Our Ref: LU/356/19/HH
Your Ref:

Town & Country Planning Act 1990 (as amended)
Town & Country Planning (Development Management Procedure) (England) Order 2015
Application for Planning Permission for Works or Extension to a Dwelling

Development Install of two front steps with handrail
Location 30 Carvel Way Littlehampton

Scale: 1:500 @ A4

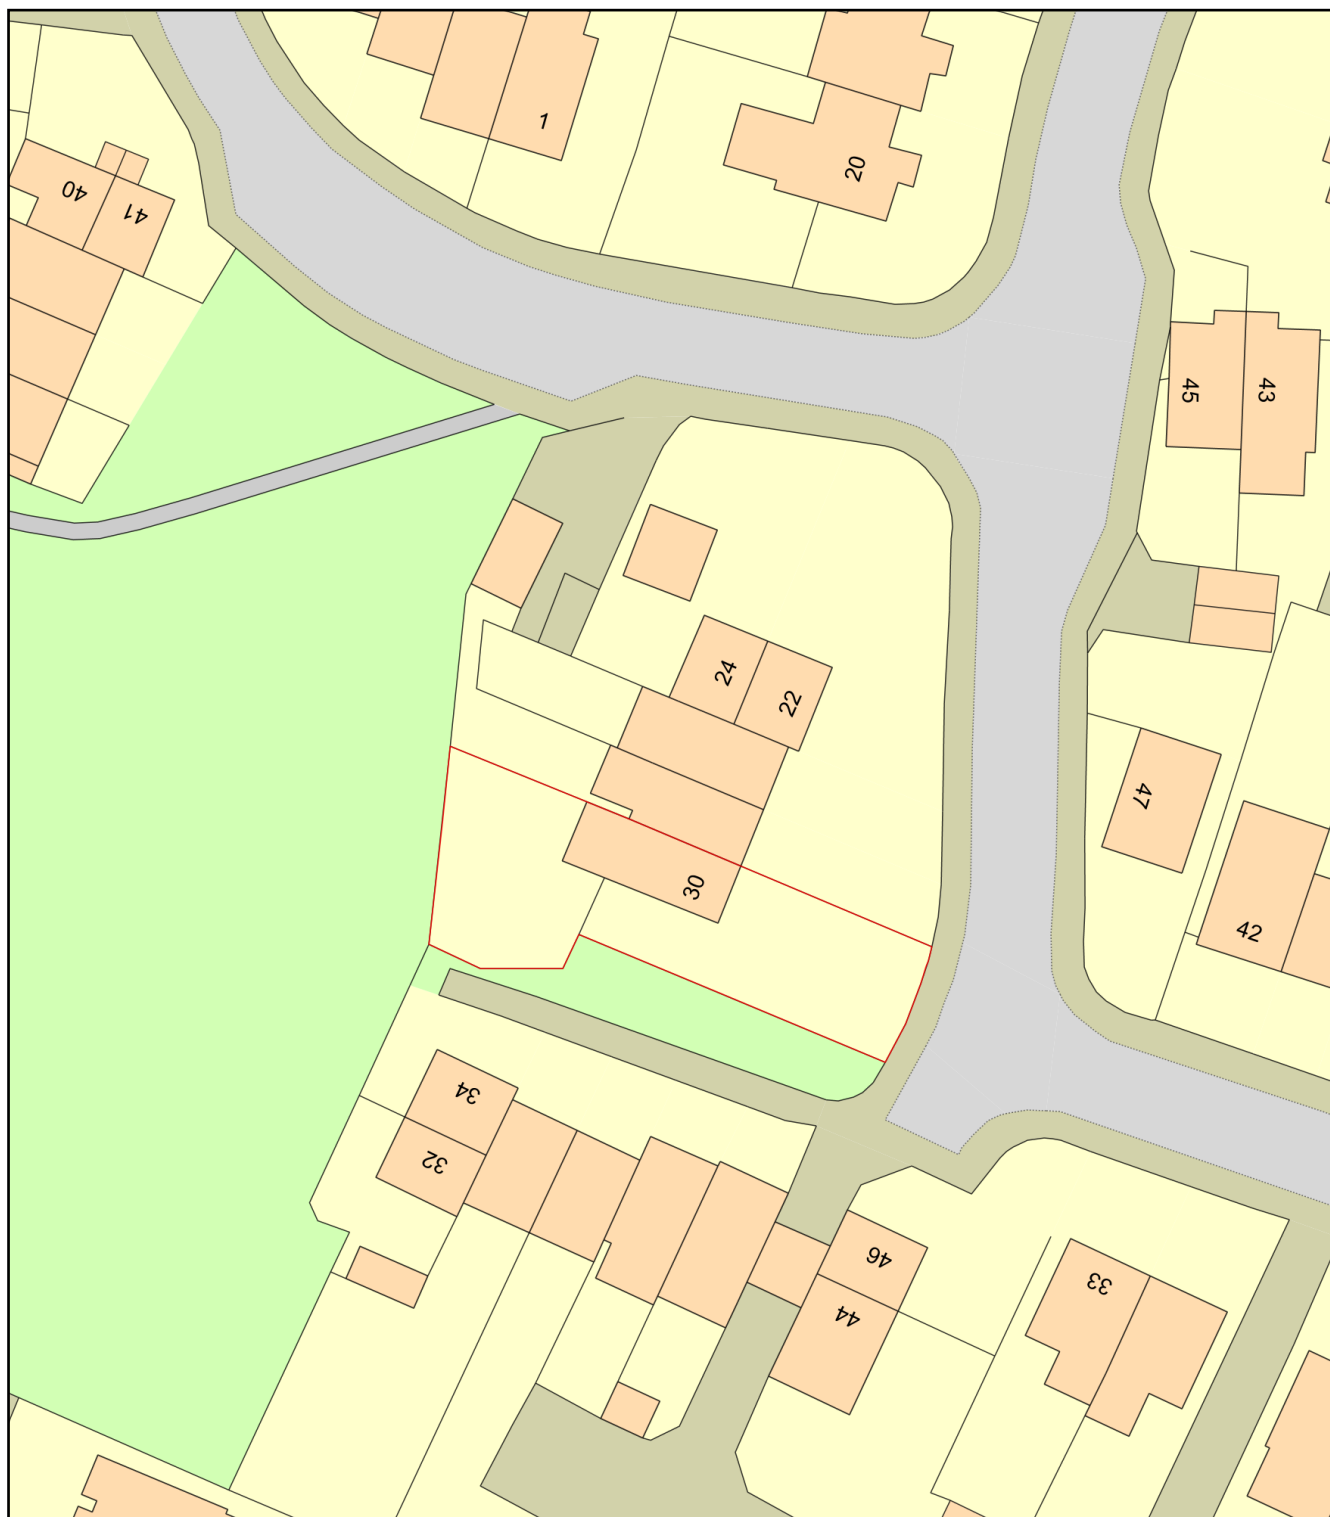
Block Plan: You are required to have dimensions from the proposed extensions to all site boundaries on the block plan. Please amend.
